Document DCO 7.1 / MCO 7.1

Applicant's response to the s51 / 55 advice

FEBRUARY 2026

The East Midlands Gateway Phase 2
and Highway Order 202X and The East Midlands Gateway
Rail Freight and Highway (Amendment) Order 202X

# Appendix 6d.5 – ES Link ID Locations Around Melbourne

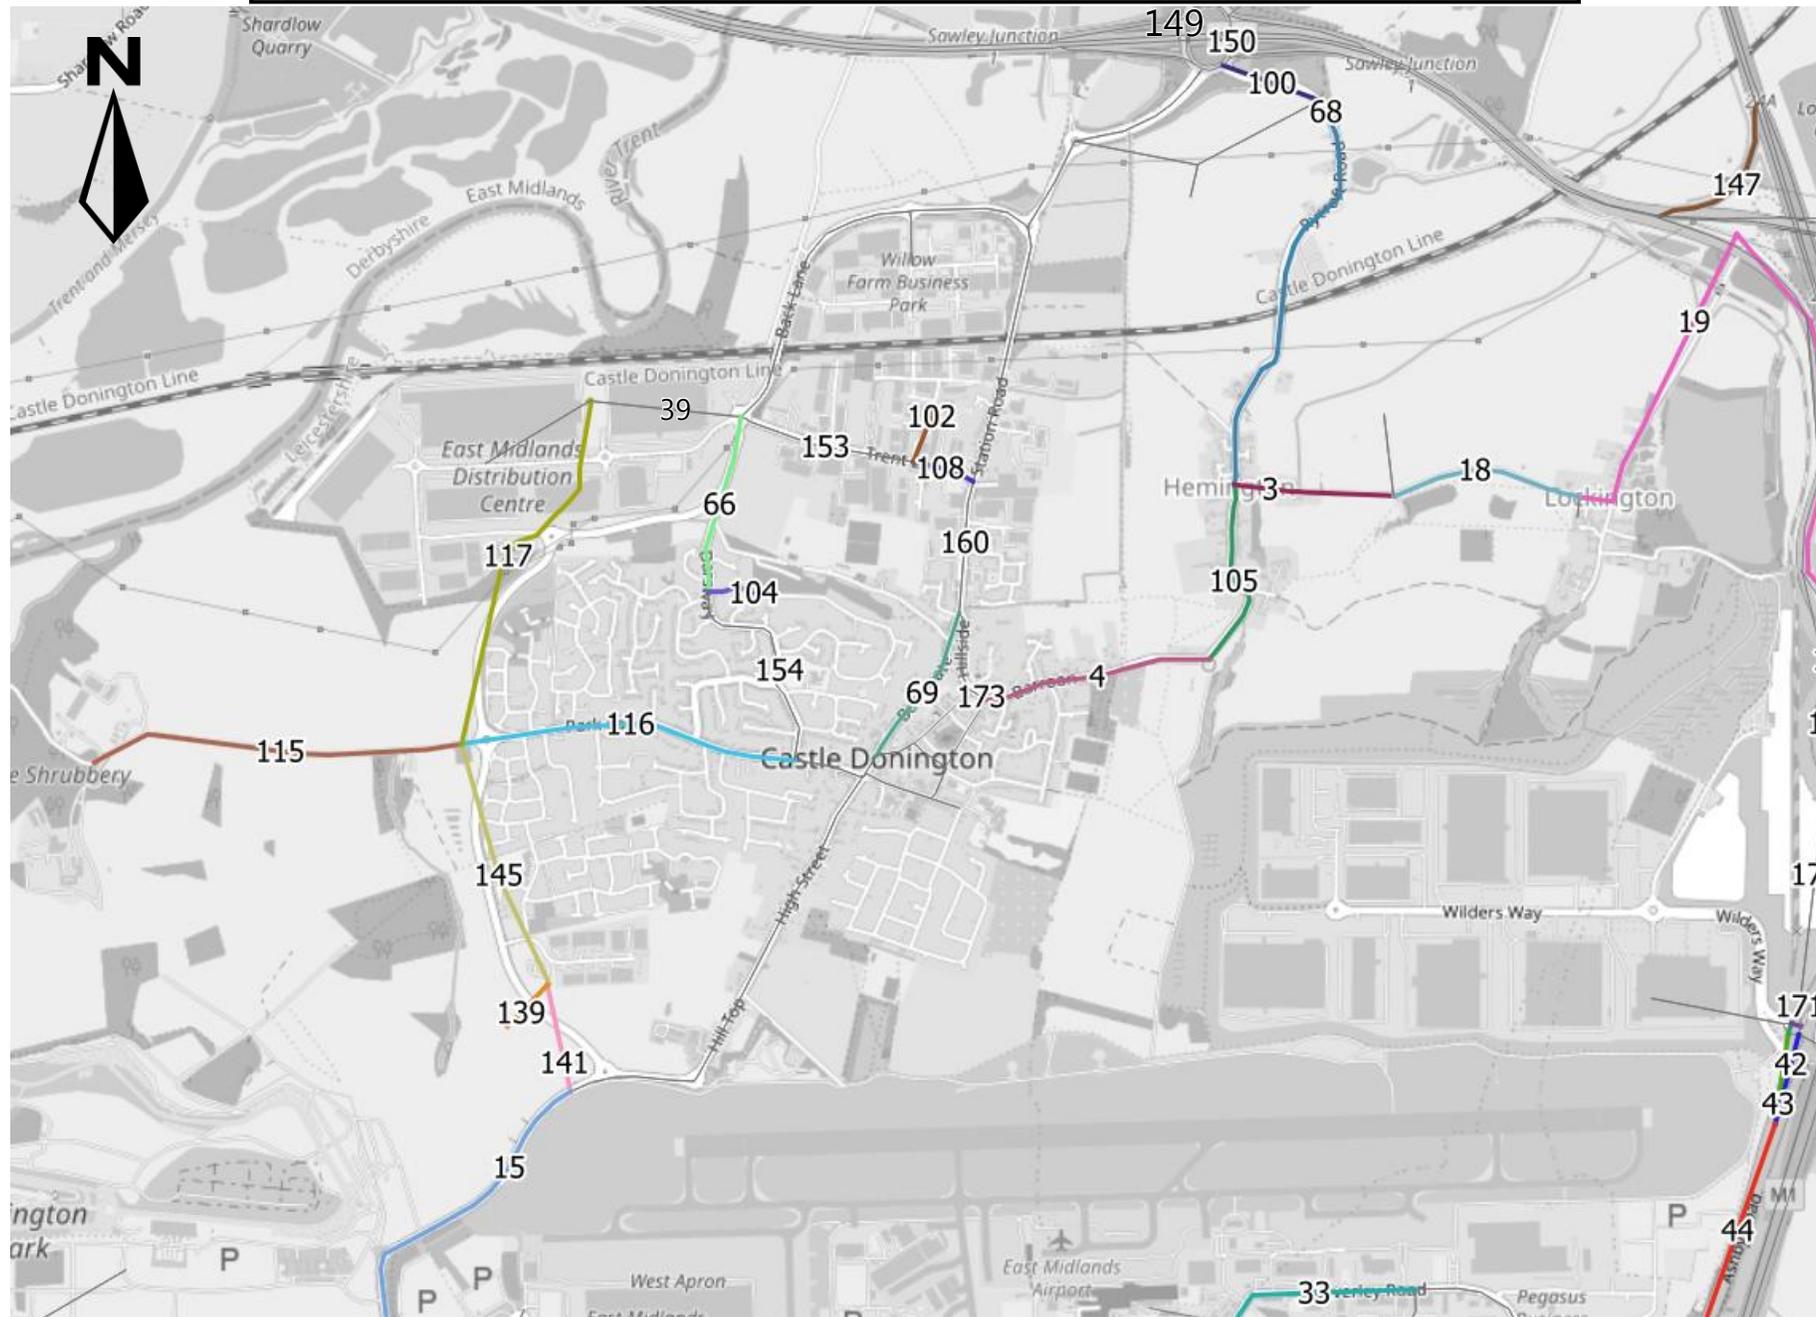
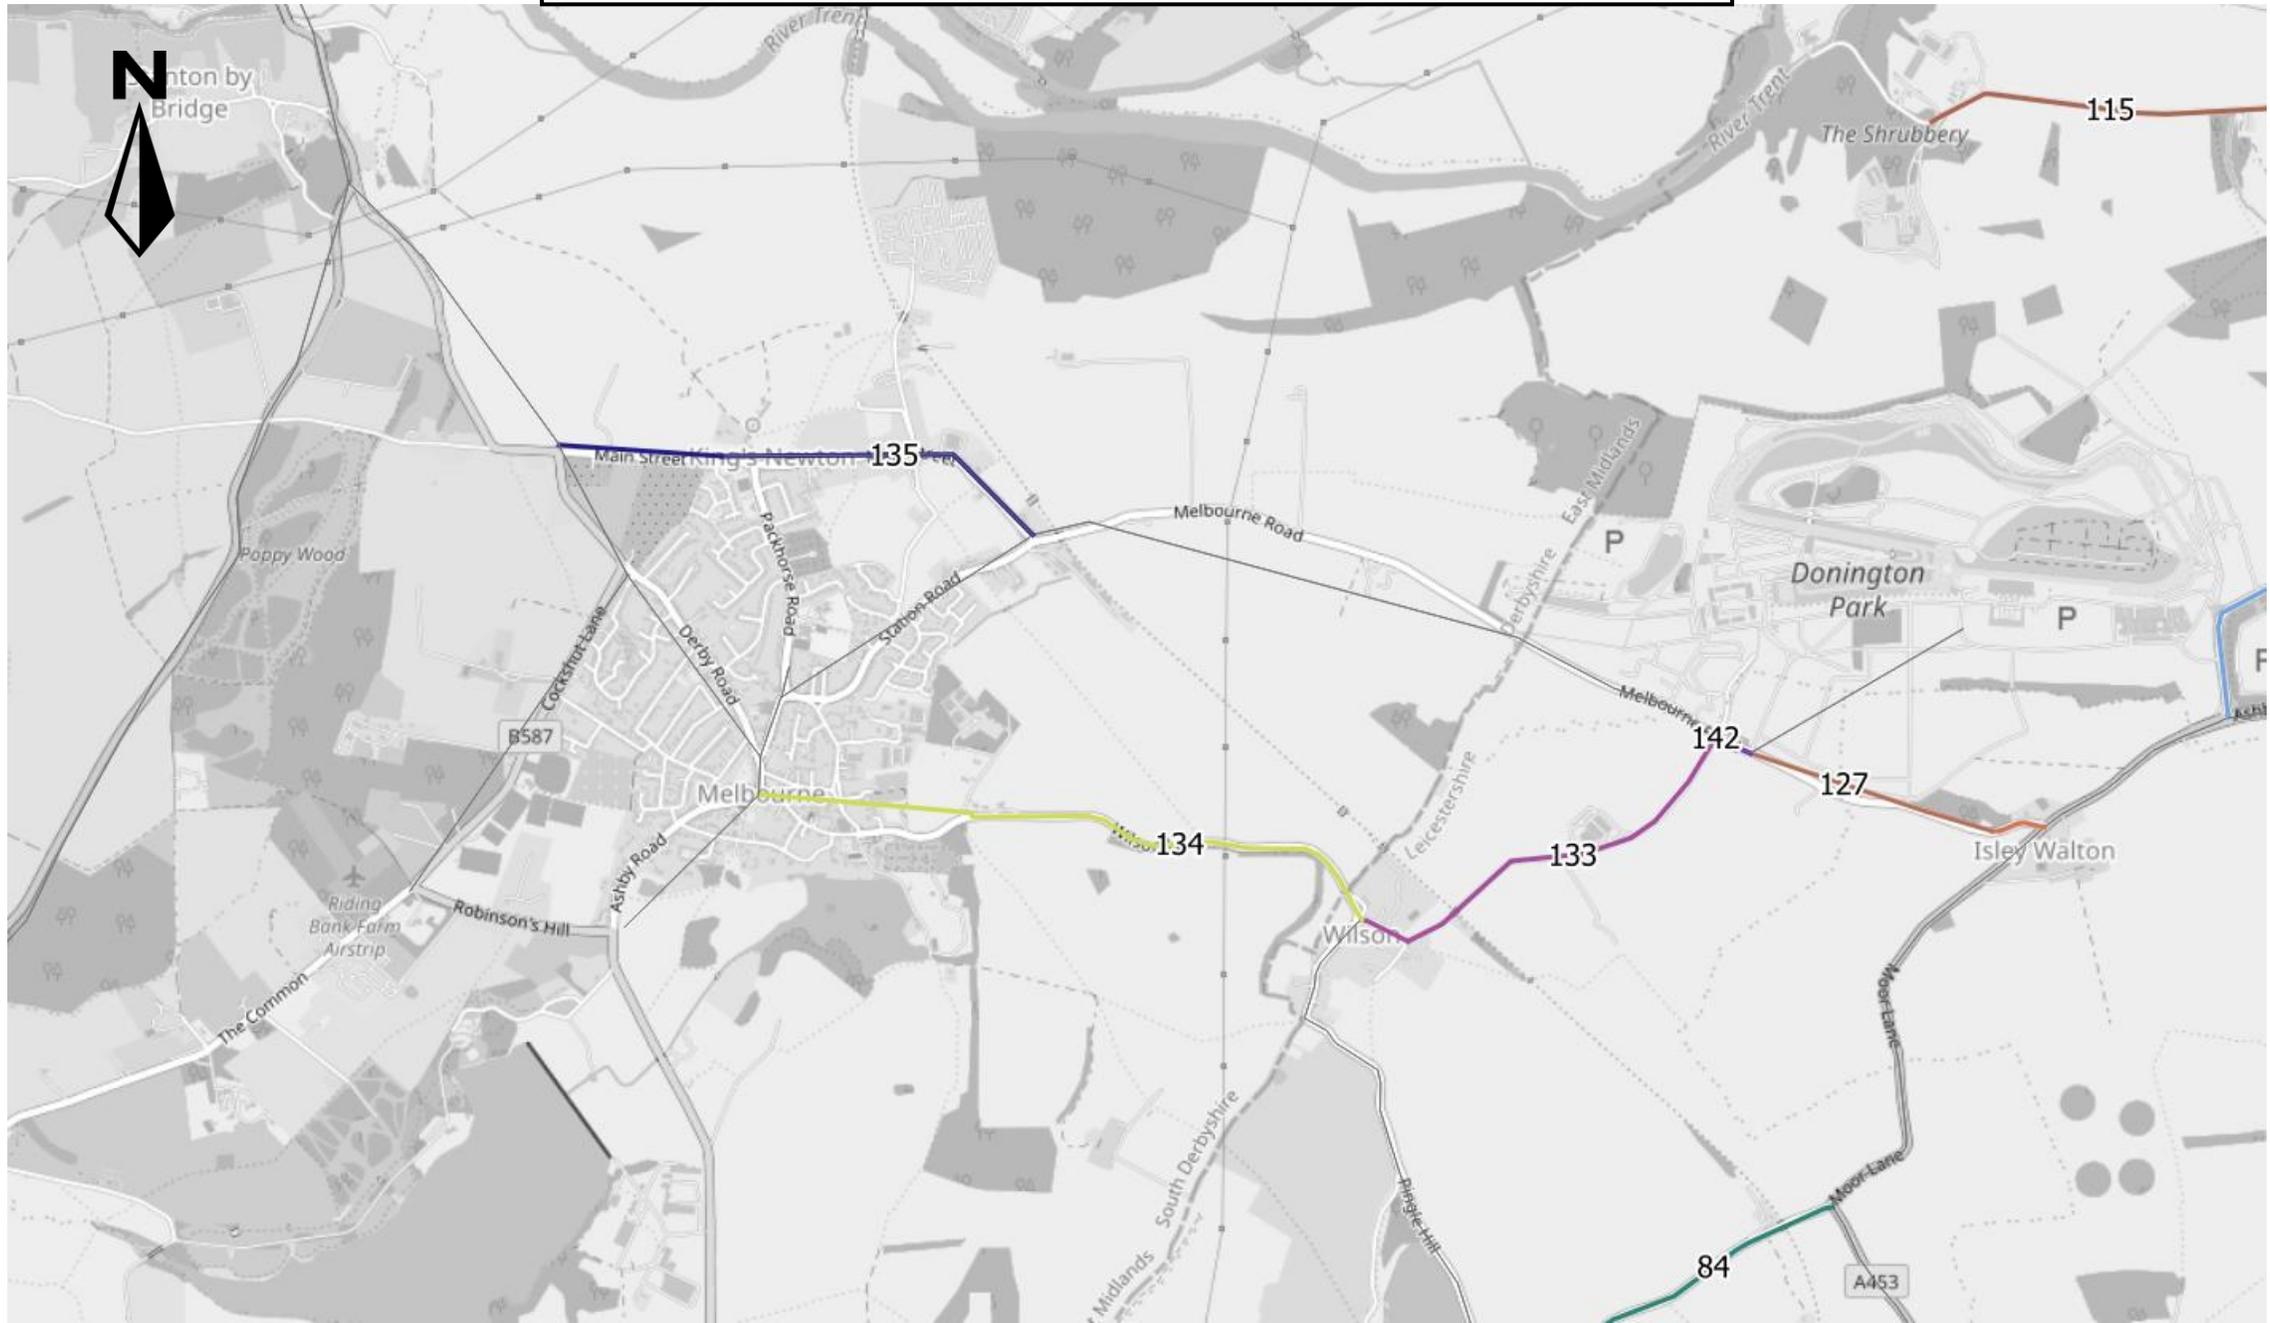
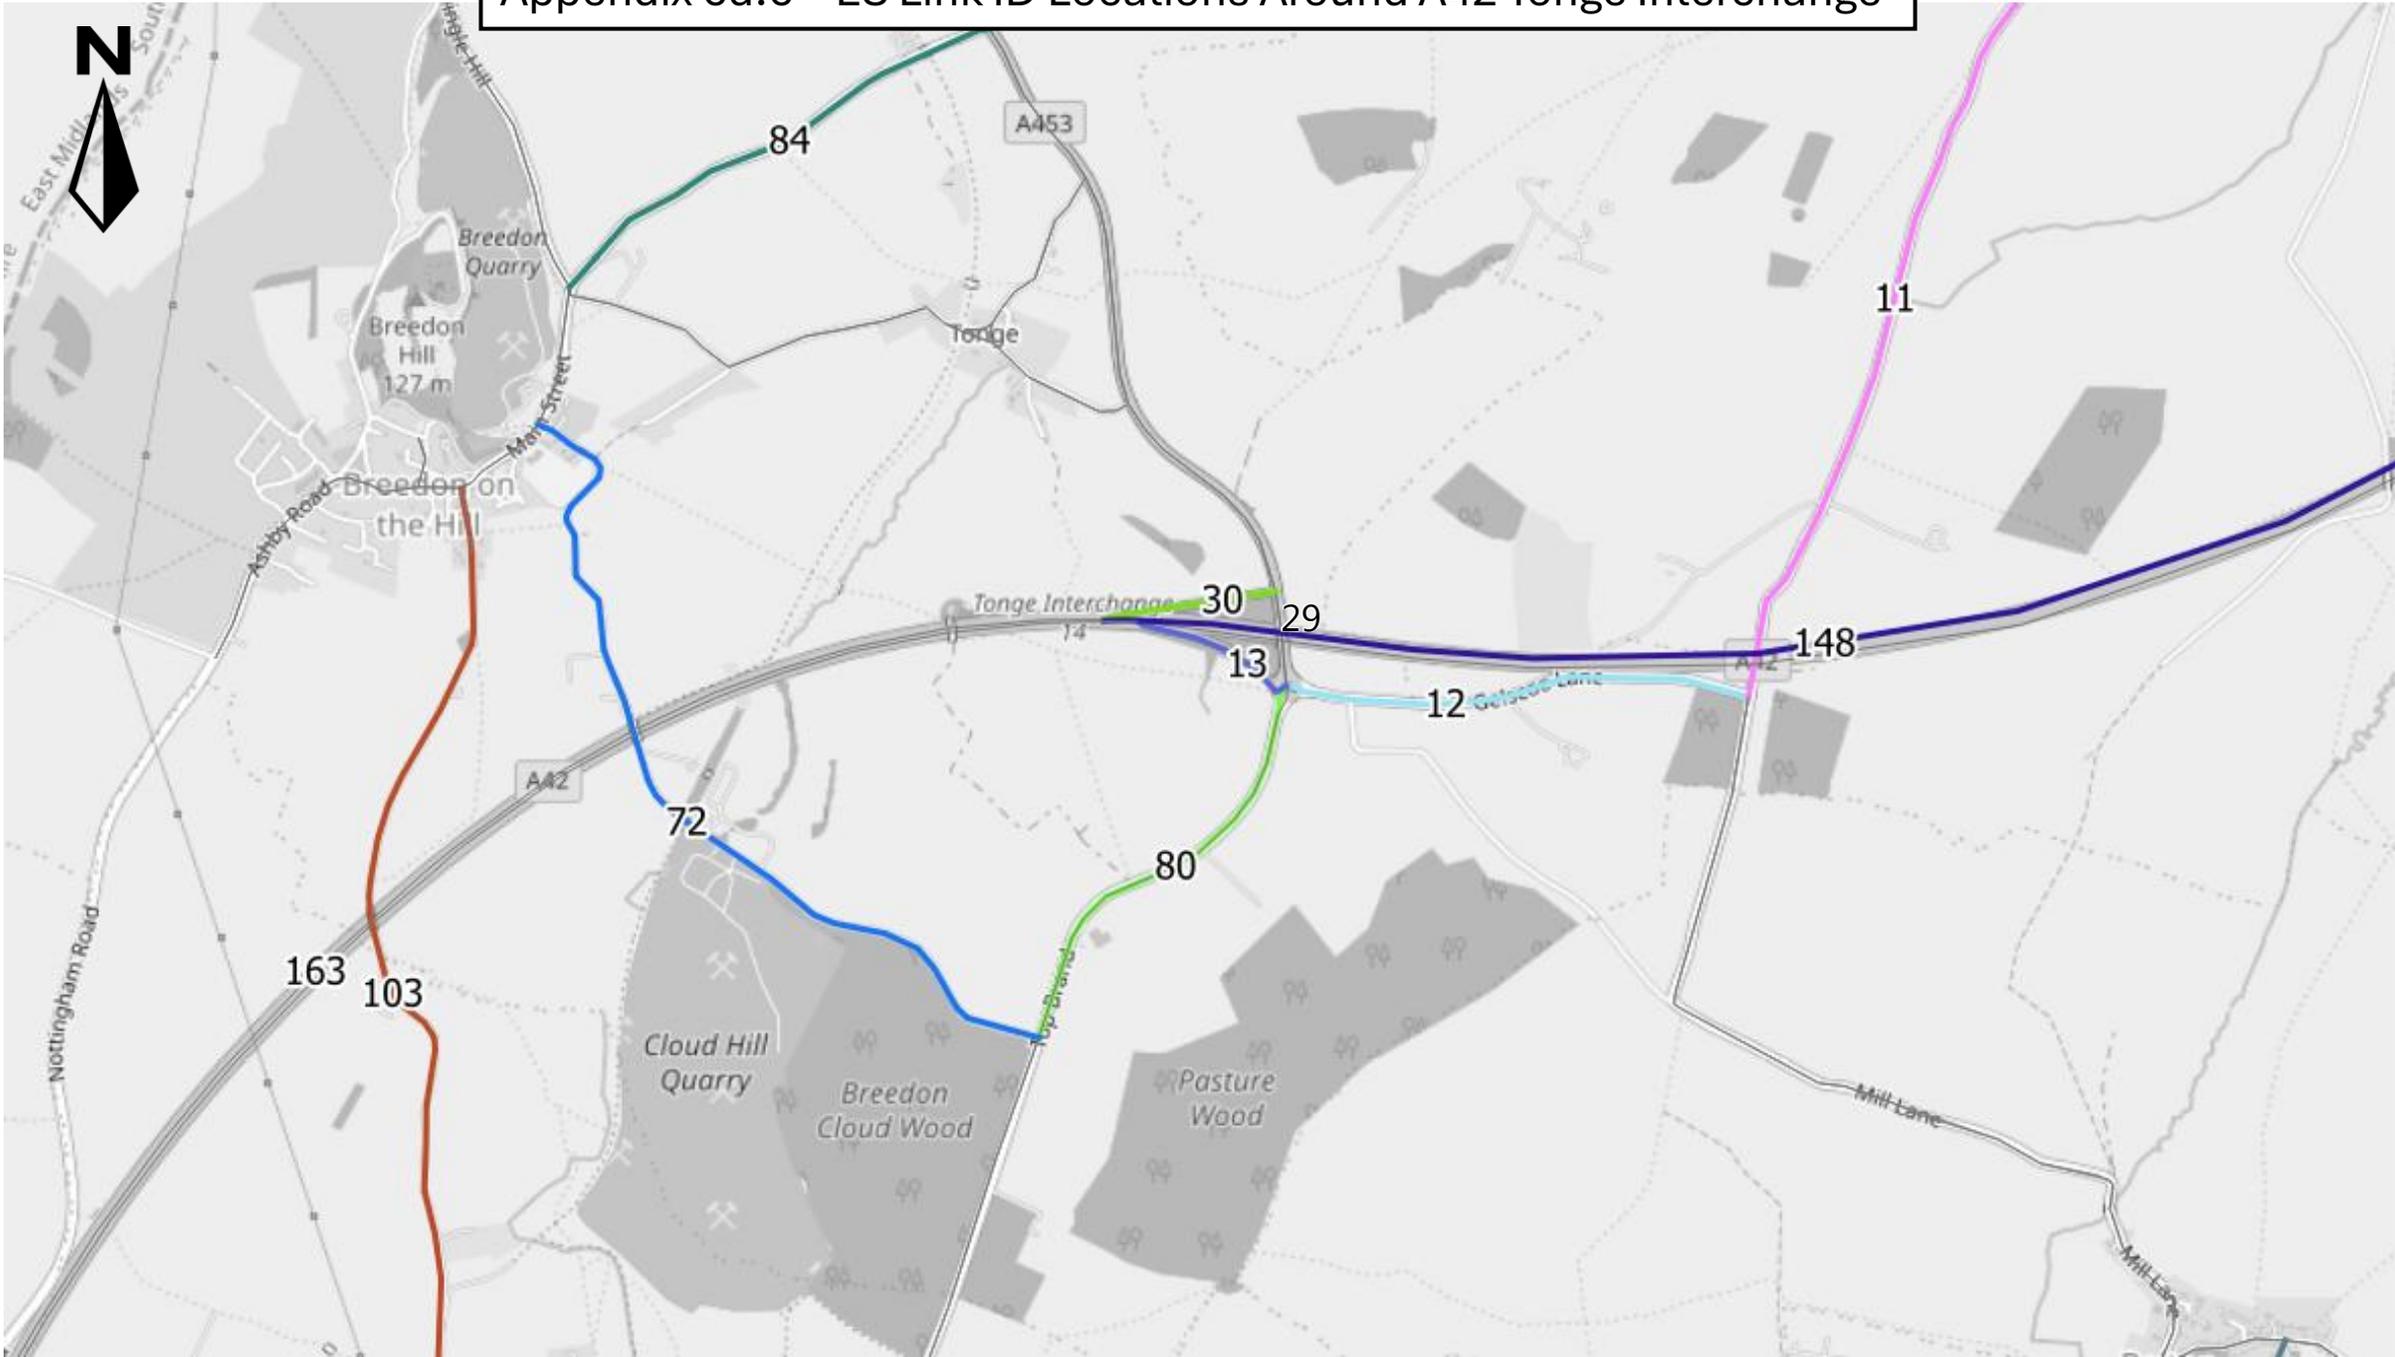
36.	i. Check and correct the description of highways links 141 and 145, described as Kegworth bypass but shown in Castle Donnington, in Chapter 6 tables 6.9 and 6.14 and Appendix 6.6D	Environmental Statement	6.6 and 6.6D	The tables in Chapter 6 and Appendix 6.6D have been corrected.

37.	ii. The links listed in the s55 comments are numbered in tables 6.9 and 6.14 but not shown at all or clearly in Appendix 6.6D	Environmental Statement	6.6 and 6.6D	Appendix 6.6D has been updated. The table at Appendix 4 lists all of the links identified and provides a cross reference to the figure depicting the relevant link.
